Re: Project Name: File No.: 3BR Custom Cuts (CU-23-00001)
Applicant: Scott Toland (Land Owner)

We represent Wilson Creek Neighbors¹ and provide this comment on *Notice of Application: Re-Notice* issued on December 19, 2023, with respect to conditional use permit application submitted by Scott Toland for design and construction of an Agricultural Processing Facility located at 3200 Wilson Creek Road, Ellensburg, WA 98926 (Assessor Parcel No. 214534). The project was re-noticed due to significant changes in the design of the Agricultural Processing Facility including the addition of a 50,880 square foot “Aerated Wastewater Storage Pond” and associated treatment processes and facilities.²

**3BR CUSTOM CUTS  
PROCESSING PLANT**

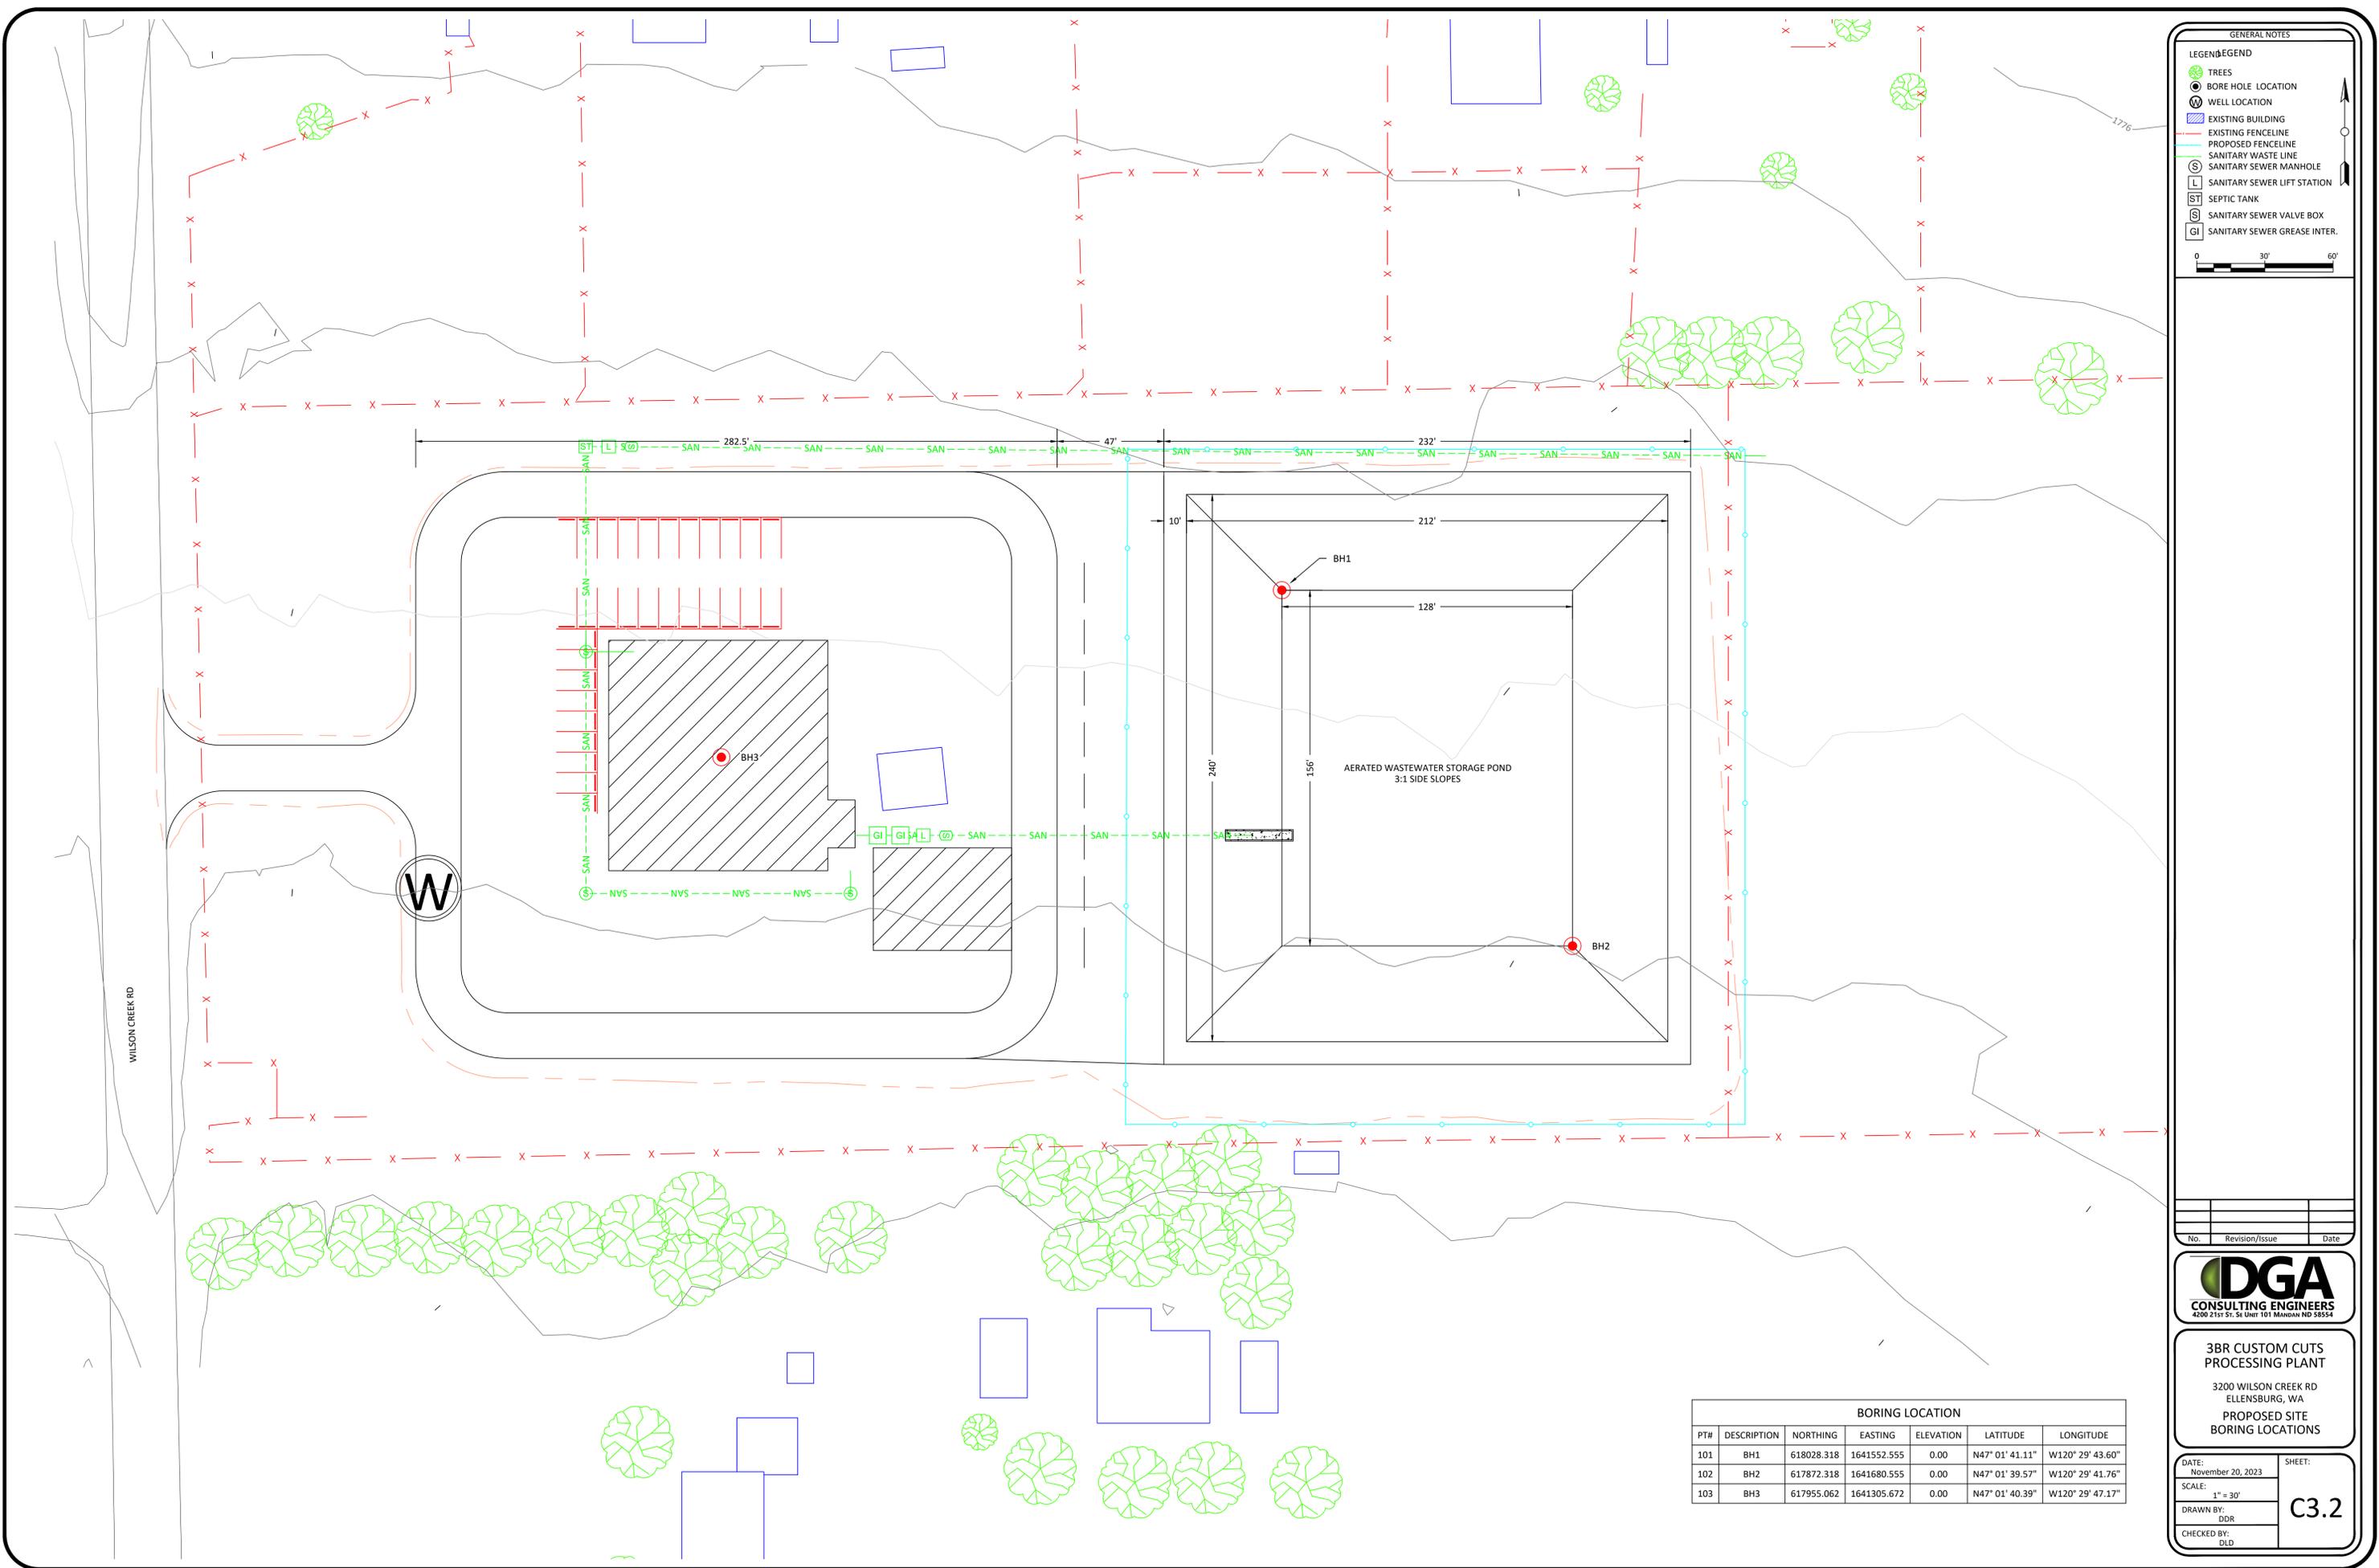
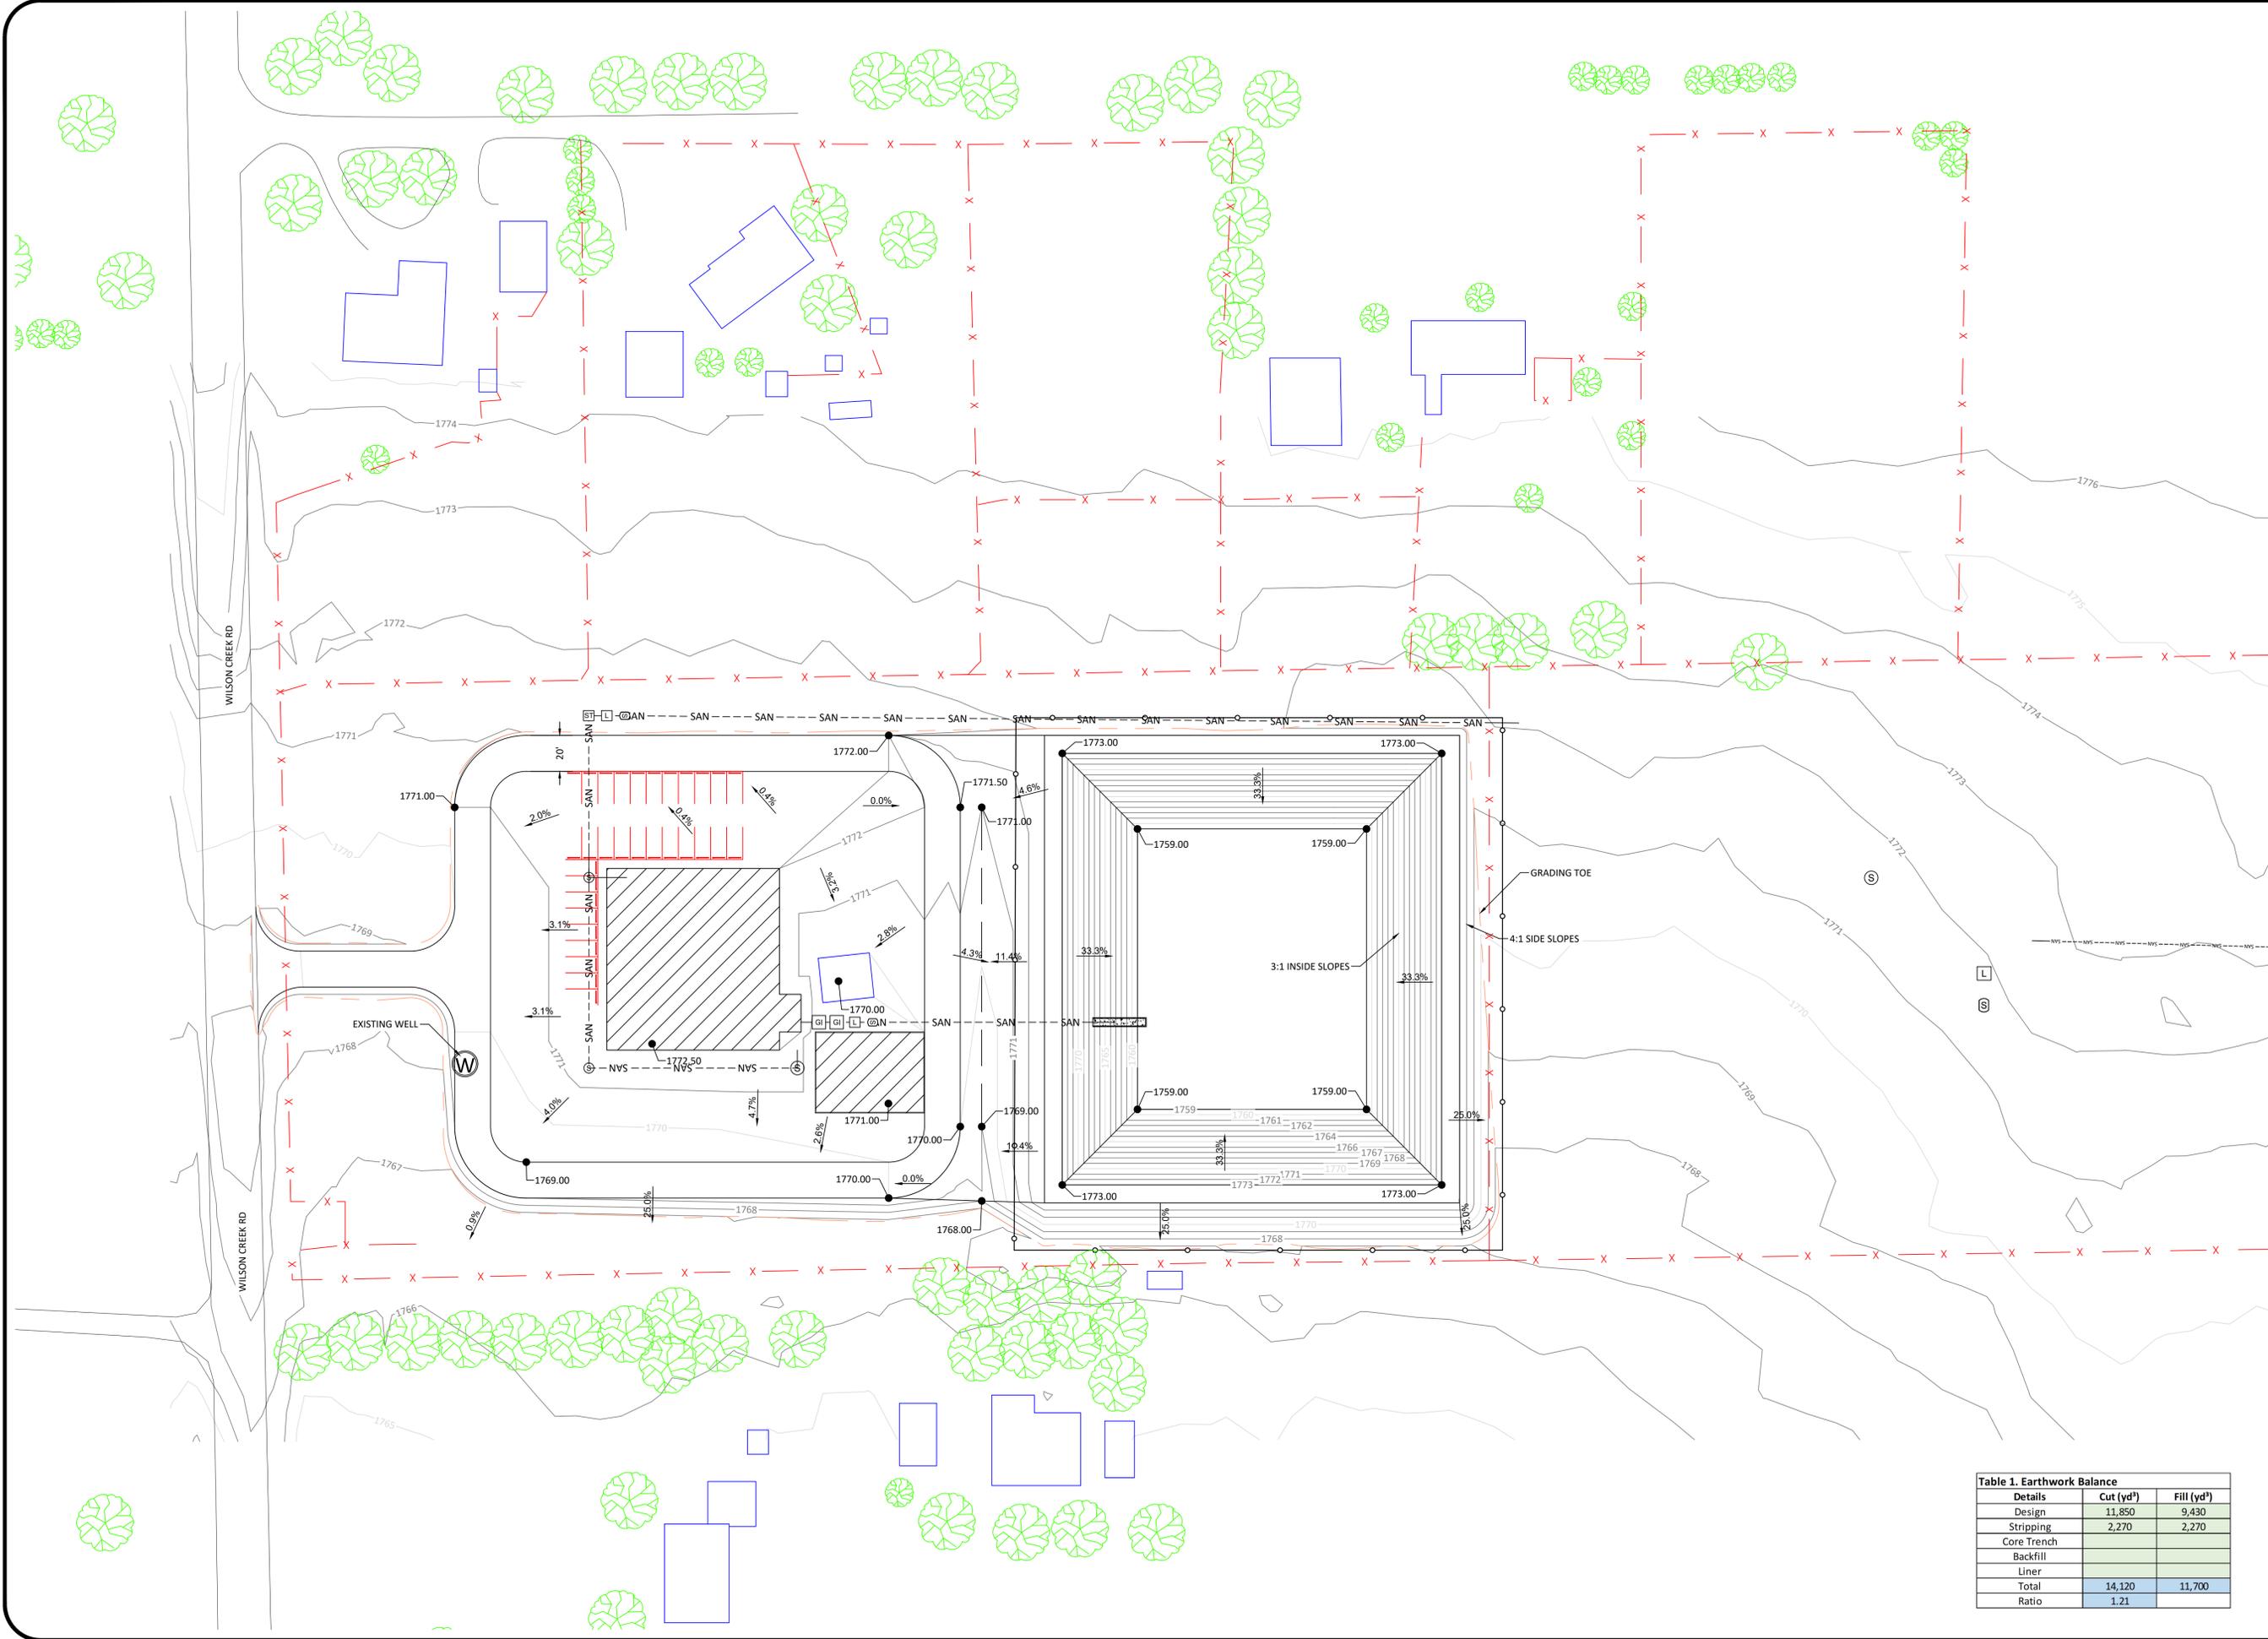
KCC 15A.03.030(2). The submitted site plan does not identify changes to the original site plan, property lines, setbacks, drain field location, areas for wastewater application, or natural features such as contours, streams, and wetlands. Also ignored were wetlands even though the property include "Wetland Investigation Area". A wetland delineation and report is required for the land use application. Site development and improvements are also located within areas of identified wetlands; a small glimpse of this can be seen in the below .⁴

No grading information is prepared for roadways, processing plant, parking lot or holding pens. Three "boring locations are identified" but no associated material provided with respect to the purpose, scope and extent of such borings and reports. Applicant also makes an indication of a proposed swale alongside the proposed facility, with no information as to grading or excavation.
